DECISION DELEGATED TO HEAD OF PLANNING

Application No: H20-0239-26 **Applicant:** Mitch-Tech Group Ltd
Proposal: Change of Use of Barn to Flexible Commercial Use
Location: Lynn House Mill Lane Sutton St James
Terminal Date: 25th May 2026

Existing Barn Structure

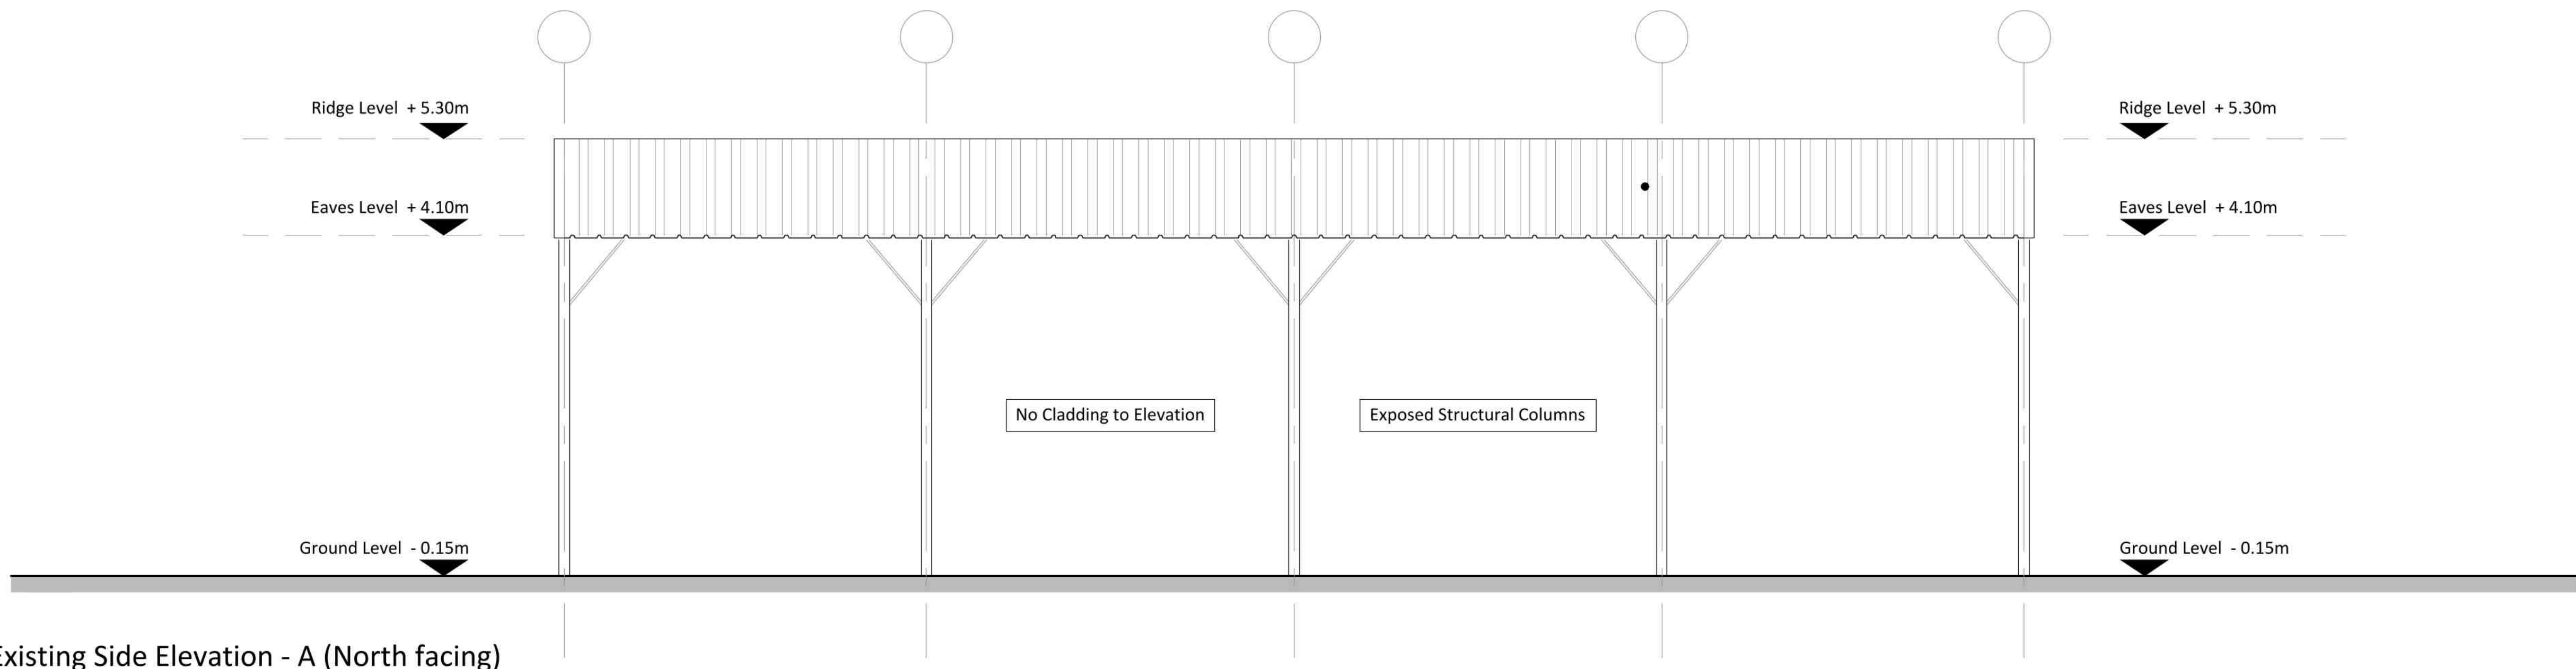
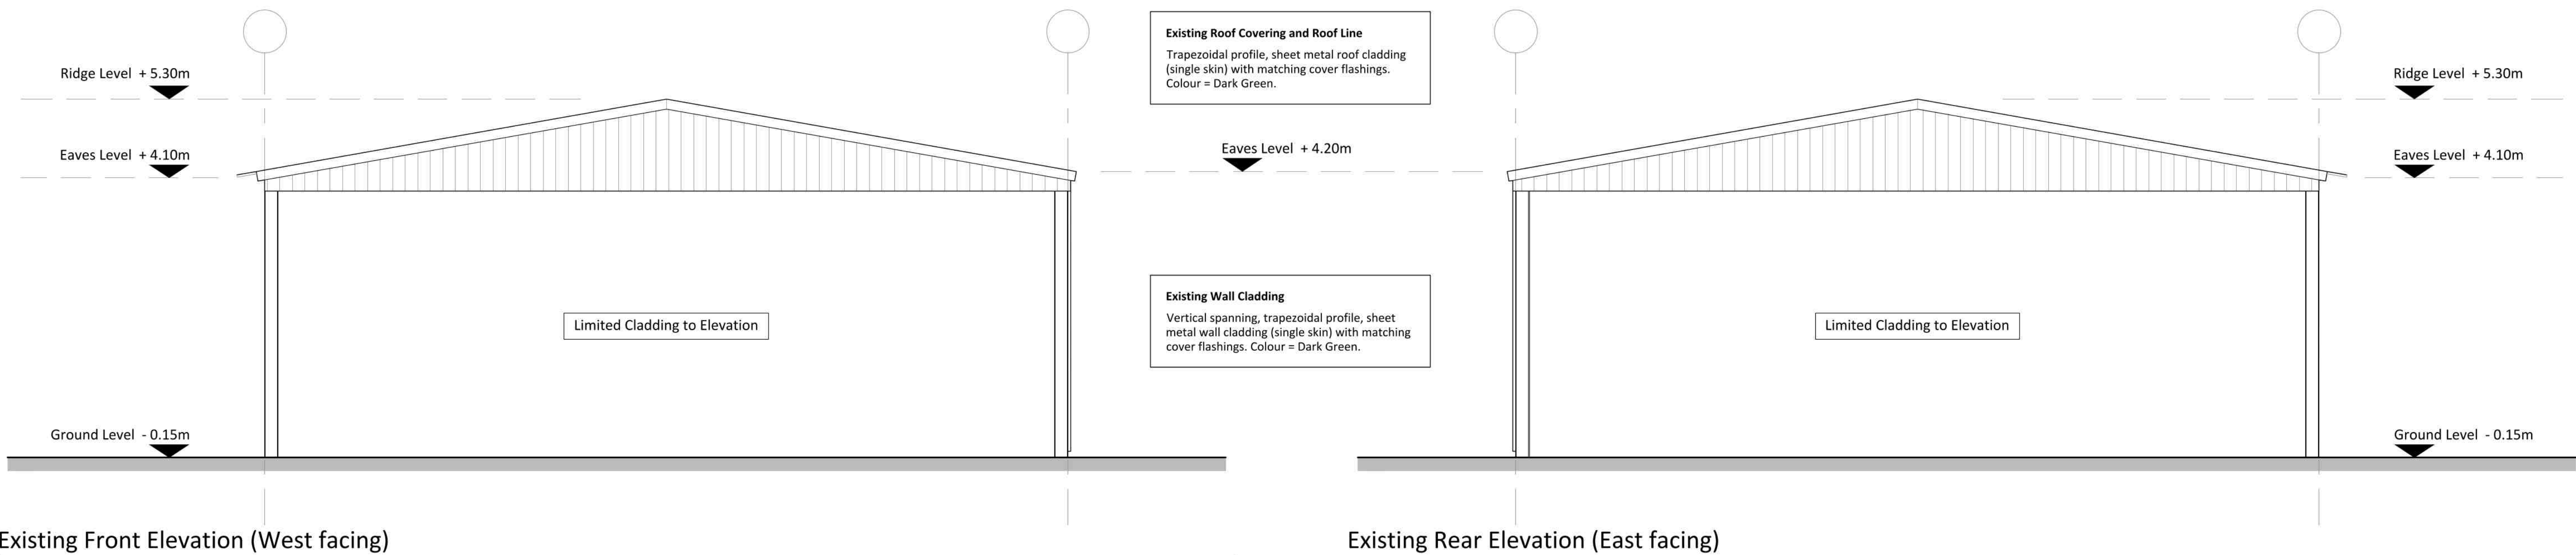
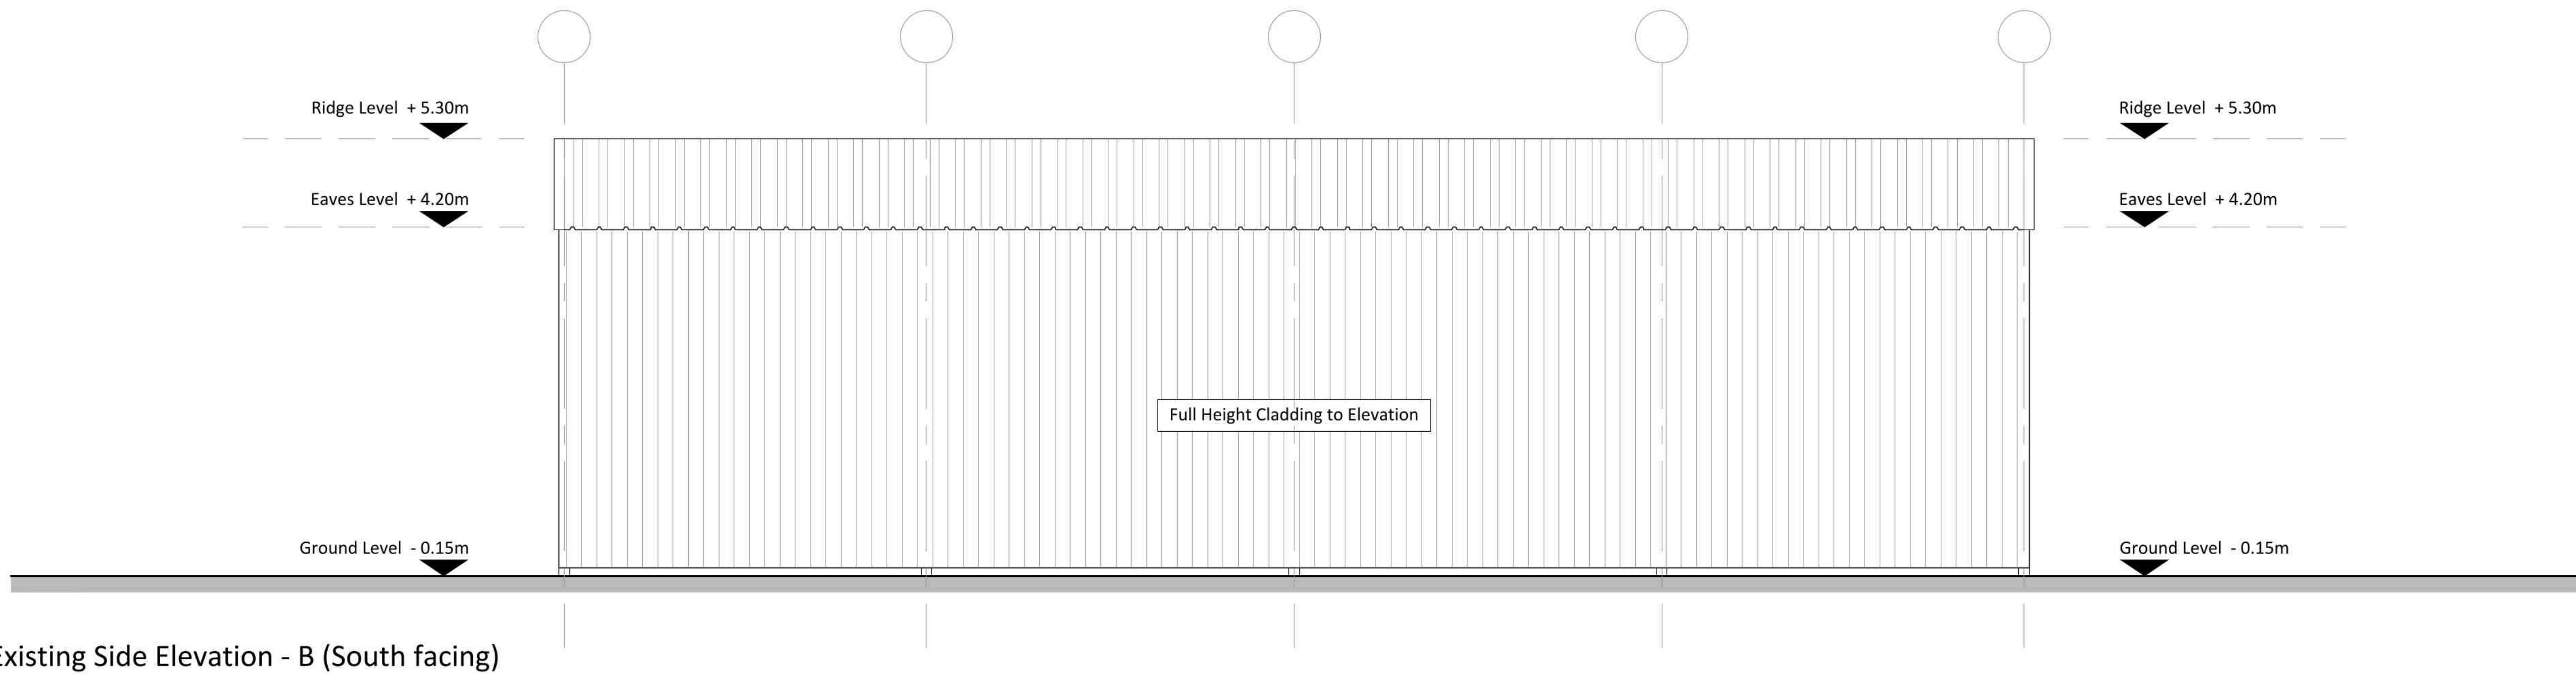
It is considered that the recladding shown on the submitted drawings would constitute operational development. The building is an open fronted barn. The proposal would enclose the structure and also raise the roof slightly. This is considered to materially effect the appearance of the building, and would therefore constitute development.

That being said, as previously outlined, operational development does not form a part of the considerations of this application and would require separate permission. Application reference H20-0372-26 has sought to address this need. The proposed elevations forming part of this application can therefore be considered as indicative only.
